DRAINAGE AND TRANSPORTATION INFORMATION SHEET

RE: GOLF COURSE + WESTSIDE COMMERCIAL SUBDIVISION
10850 GOLF COURT RD. NW
ENGINEER'S STAMP DATE: 9/14/22
HYDROLOGY FILE: A12D008B2

Per the correspondence dated October 11, 2022, please find the following responses addressing the comments listed below:

Drawing file: Final / A12D008B2 Conceptual G&D 22.11.16.pdf

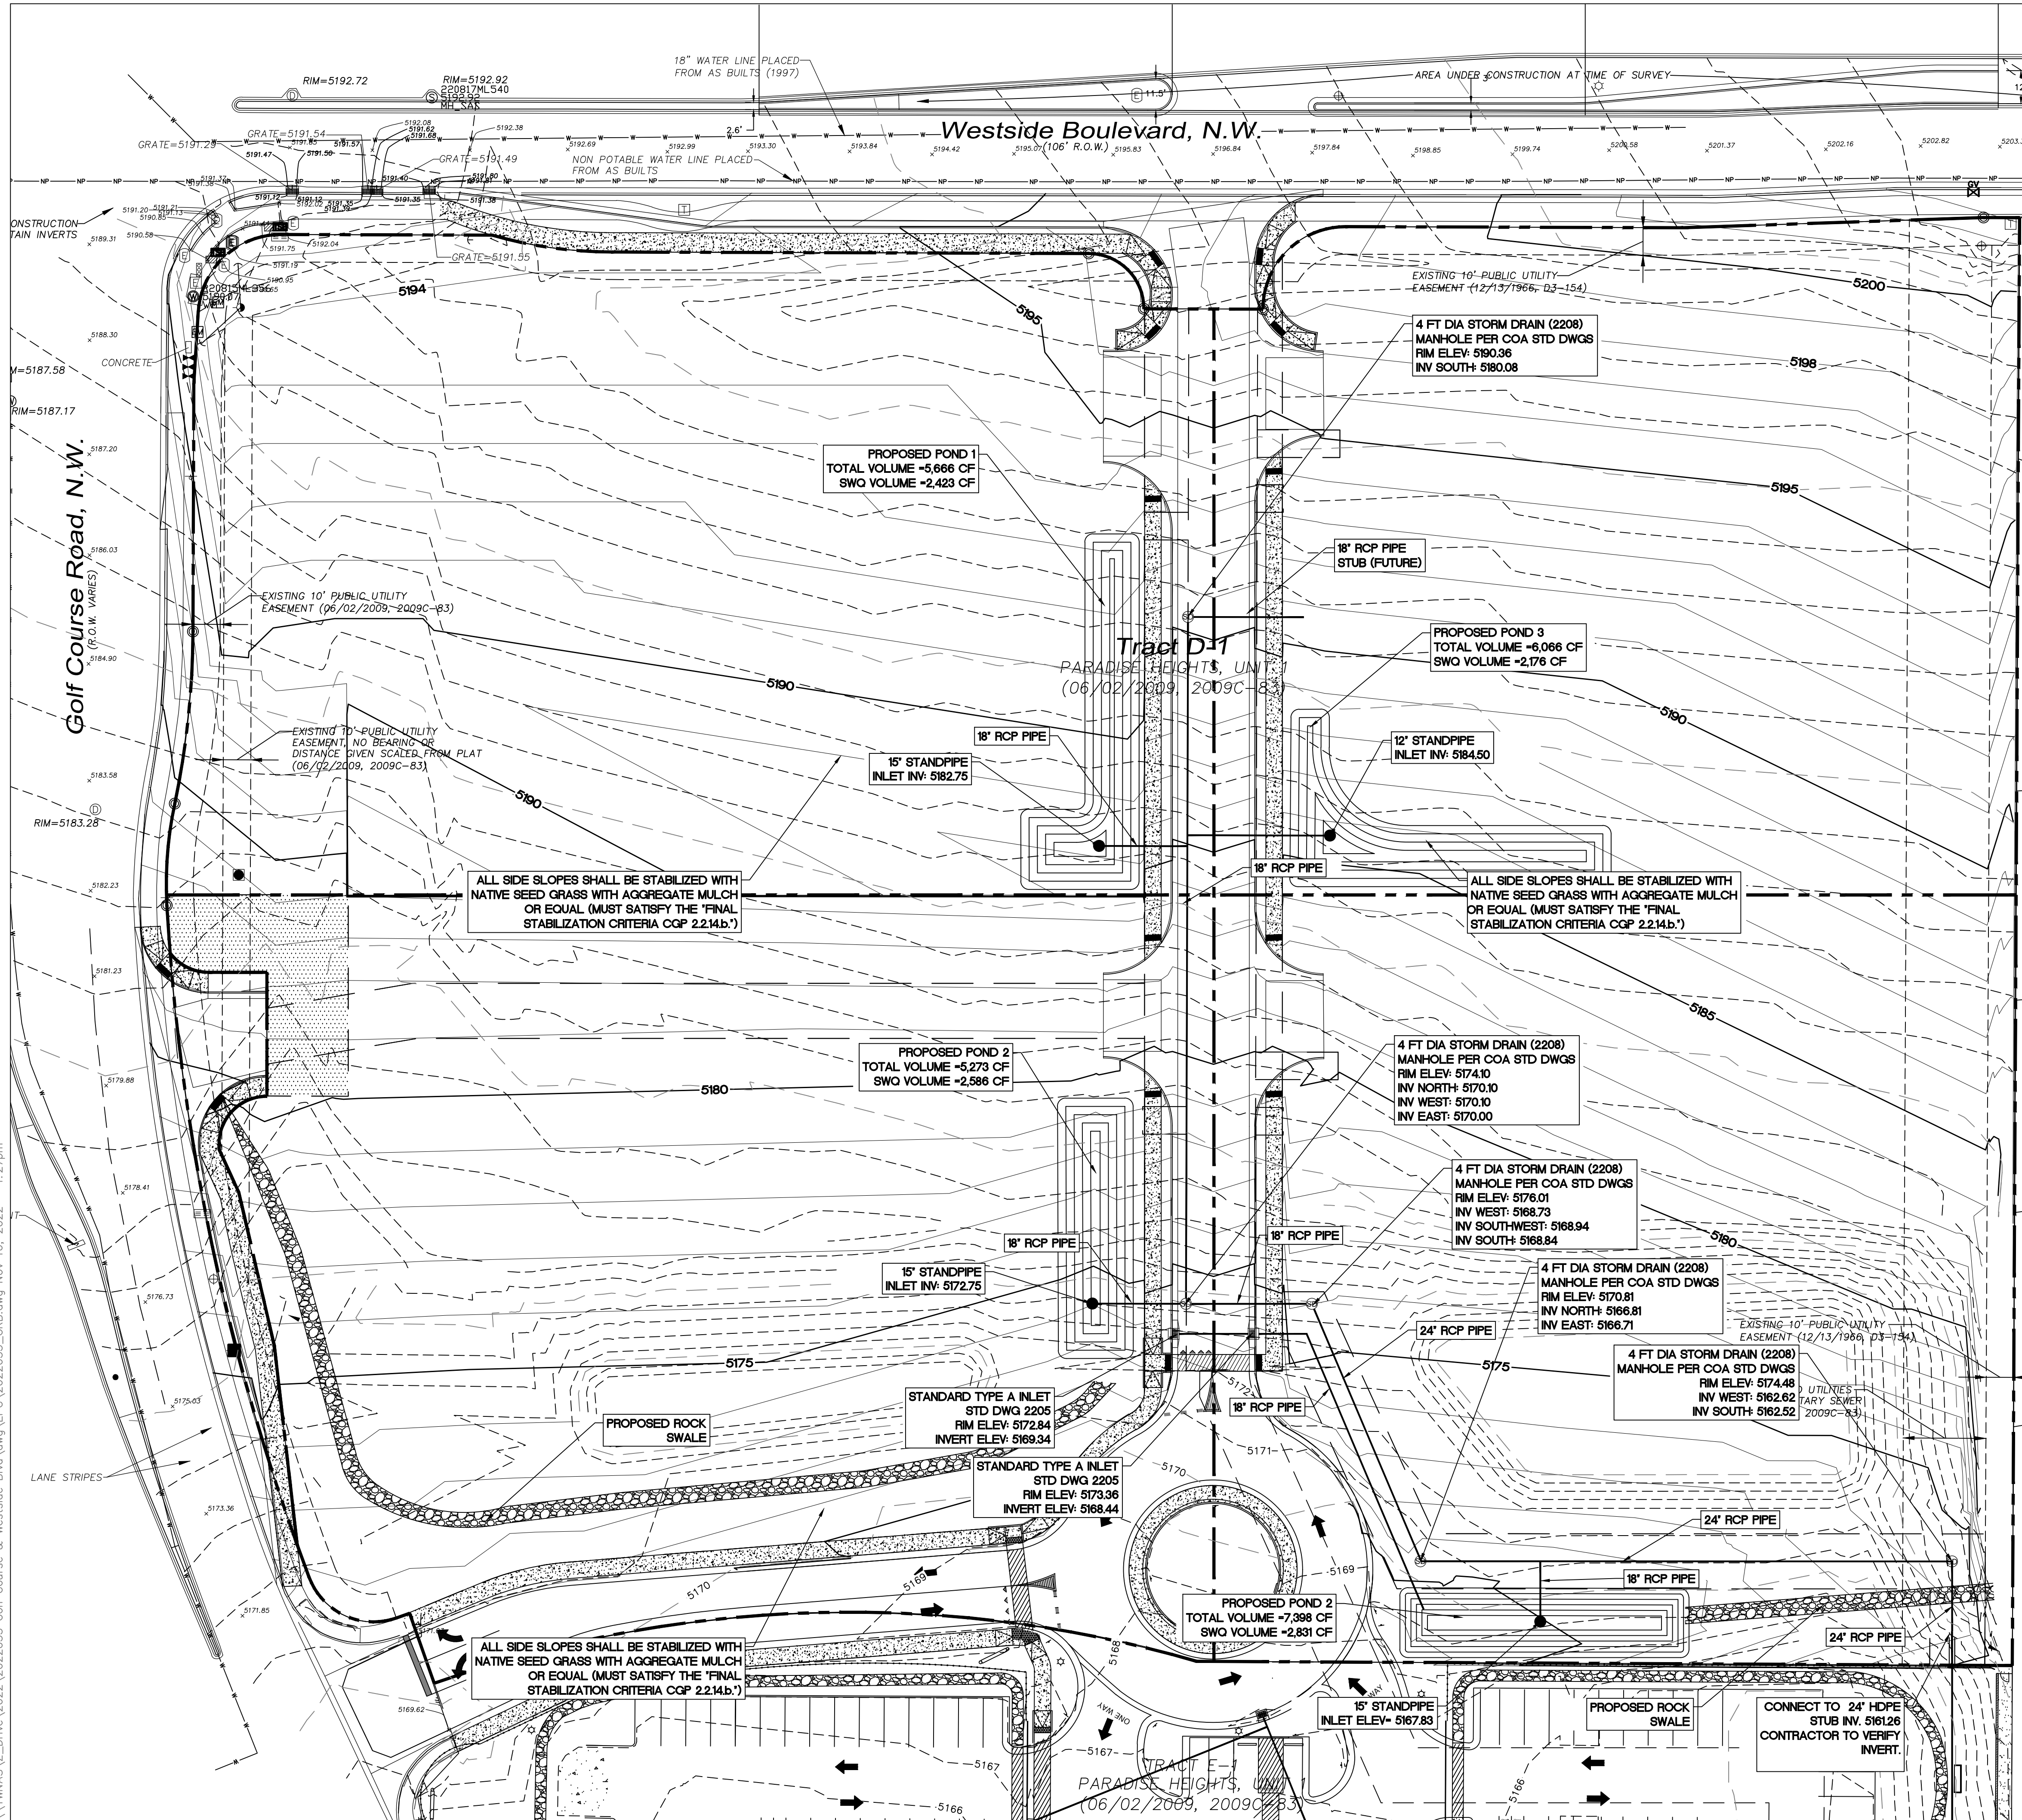
3. Ponds 1, 2, 3, and 4 appear to be included as part of the subdivision infrastructure and, as such, should include permanent pond stabilization, and all developed stormwater runoff should be directed into a non-erosive inlet structure constructed with the infrastructure. The pond outfall structures will also be part of the infrastructure, and detailed hydraulic design calculations will be required with this submittal. Hydraulic capacity calculations and construction details of inlet and outlet structures for Ponds 1, 2, 3 and 4 are missing. Alternatively, these ponds may be deferred to the site development of each lot at the time of building Permit, so this subdivision would only construct storm sewer stub-outs to each lot and temporary 100-yr retention pond on each lot that would serve both the purpose of temporary stormwater control and Erosion and Sediment Control. A specific design for each pond should be provided now as part of a master drainage plan for this subdivision, whether the final construction of the ponds is a subdivision or building permit requirement.

6. The SWQV calculations are missing for basins D1, D2, D3, and D4. There has been no attempt to provide the SWQV for D5, but SWQV must be provided for all impervious areas. The SWQV for the undeveloped lots may be deferred to the site development of each lot at the time of the Building Permit; however, cross-lot drainage issues need to be resolved with this subdivision.

7. The drainage basin boundaries need to match the grading. Presently the basin boundaries are on the lot lines, thus indicating that there will be no cross-lot drainage and that each lot drains to its own pond and then into the common storm drain system. However, the grades show the west portion of basin D1 drains into D2 and not into Pond 1. The west perimeter slopes drain to offsite, and the south side of each lot has some slope drainage across the lot line. Identify how cross-lot drainage will be prevented or identify cross-lot drainage easements with beneficiary and maintenance.

10. Provide sections through all external boundaries showing proposed retaining walls, garden wall, property/ROW lines, and existing and proposed grades. In accordance with DPM Ch.22, section 5 part B, grading and wall construction near the property line may not endanger adjacent property or constrain its use.

RESPONSE: Acknowledged, see updated drainage report for details.

RESPONSE: SWQV calculations provided in the Appendix portion of the report. The storm water quality volume of Basin D5 is now accounted for in Pond 4.

RESPONSE: Drainage basins updated.

RESPONSE: This is referencing an old version of the IDO, and this is a conceptual drainage management plan. Final design may vary.
